Major Projects – Mixed use development at 8-16-Watt Street, Gosford (Gateway site) (SSD-10414) (EXH-8956504)

Thank you for the opportunity to review and provide comment on the Environmental Impact Statement for the above development site. Council has reviewed the information on the Major Project Planning Portal in response to your request and provides the following comments for your consideration.

CENTRAL COAST COUNCIL
SERVICE LOCATION DIAGRAM
(SEWER MAINS)
NOT TO SCALE

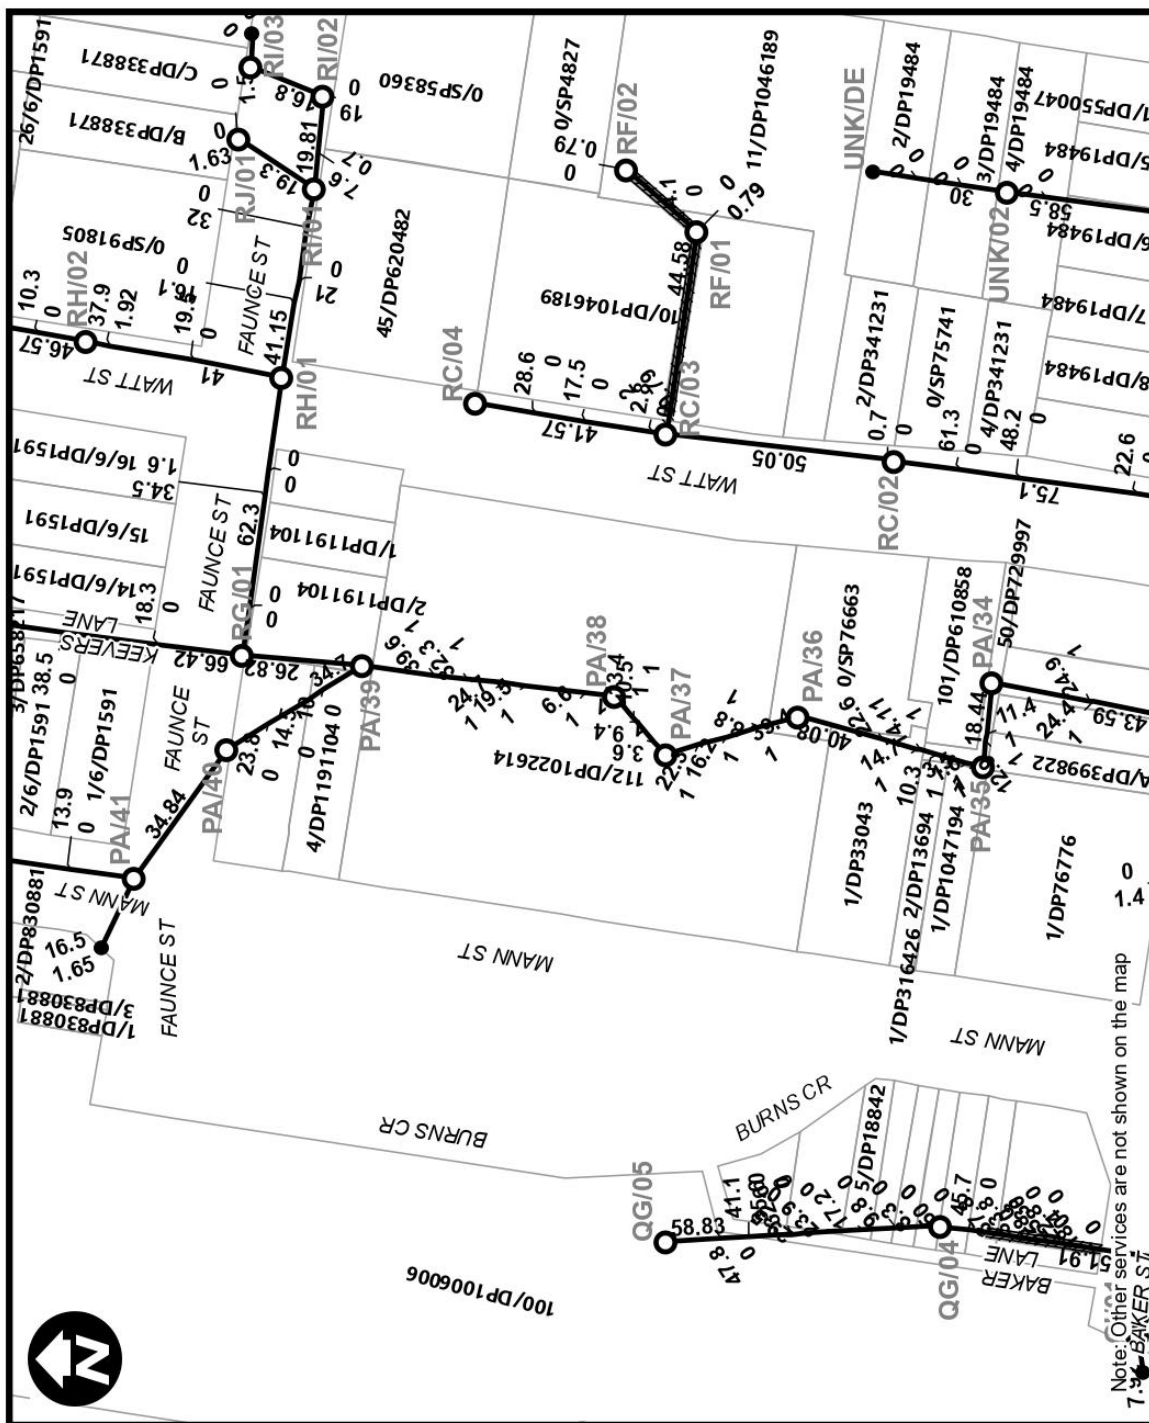
The development proposal will impact various Council sewer mains located within the development site. These sewer mains, which service existing development to the north, northwest and north east of the site, may not physically be able to be relocated without impacting third party properties situated adjacent to the proposed development. Investigations should occur at concept stage to confirm feasibility of relocation of the sewer mains and inform the subsequent detailed Development Applications.

Figure 15: Extract from Level 2 Plan identifying Vehicle Entries

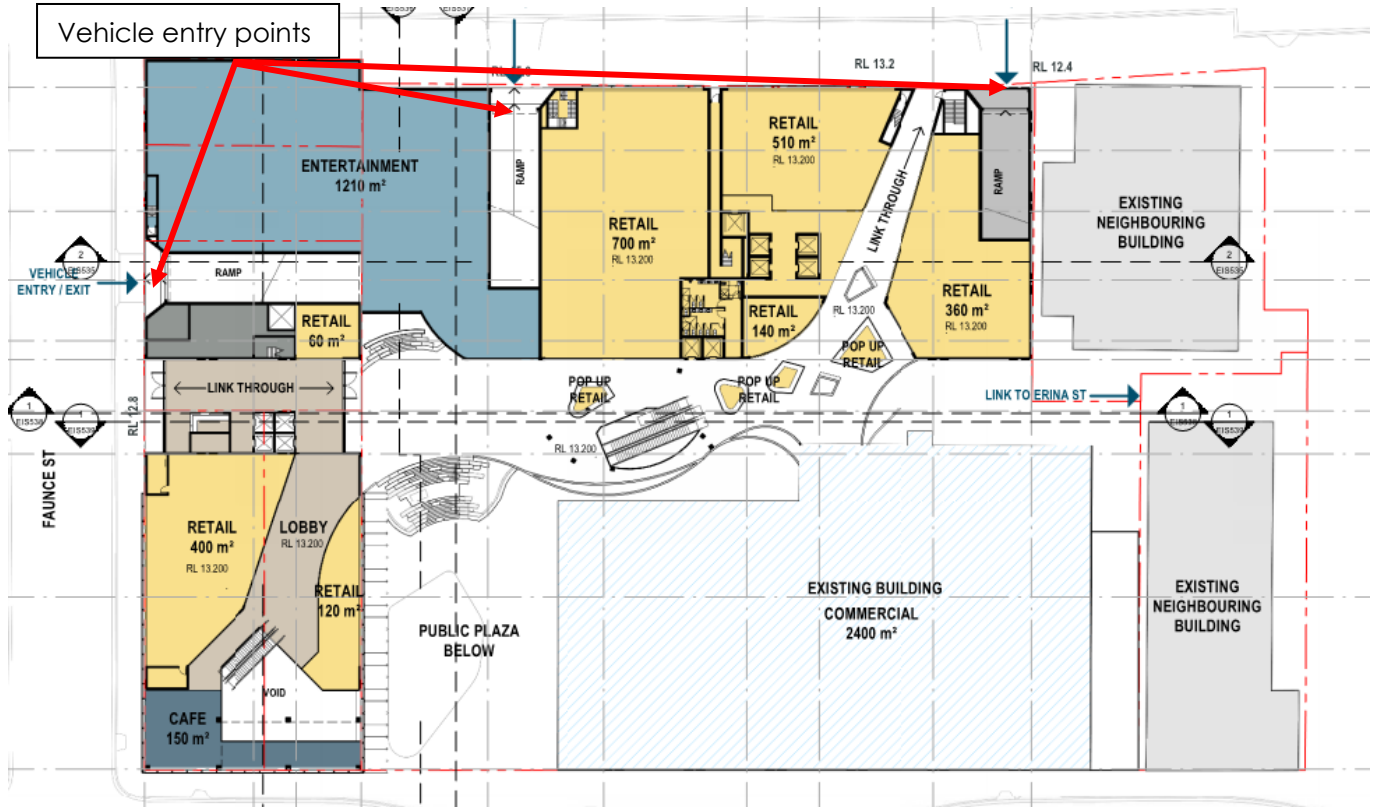
Consideration must be given to the staged construction of the basement car park. Constructing a portion of the car park beneath Tower 1A and then 1B, followed by Tower 2 does not seem feasible. It would appear from the layout that a significant portion of the proposed basement car park may need to be constructed as part of Stage 1.

- How vehicle access for waste servicing vehicles will be achieved for each stage.
- Where deliveries will be made and the size of the delivery trucks.
- The development shall be designed to permit all vehicles to enter and exit the site in a forward direction.

Figure 16: Extract from Landscape Masterplan

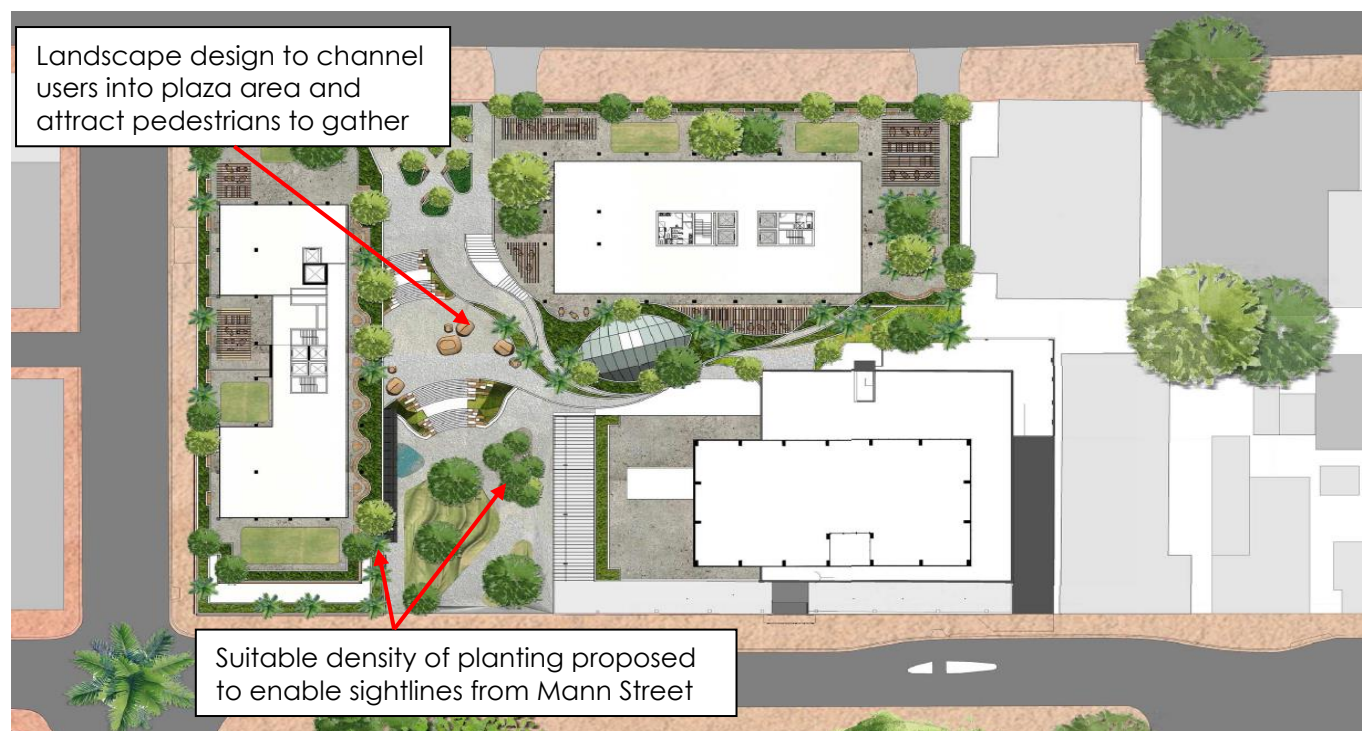
It is noted that the landscape drawings are inconsistent with architectural drawings in that they show trees on the north east corner which is occupied by the building on the adjoining site.
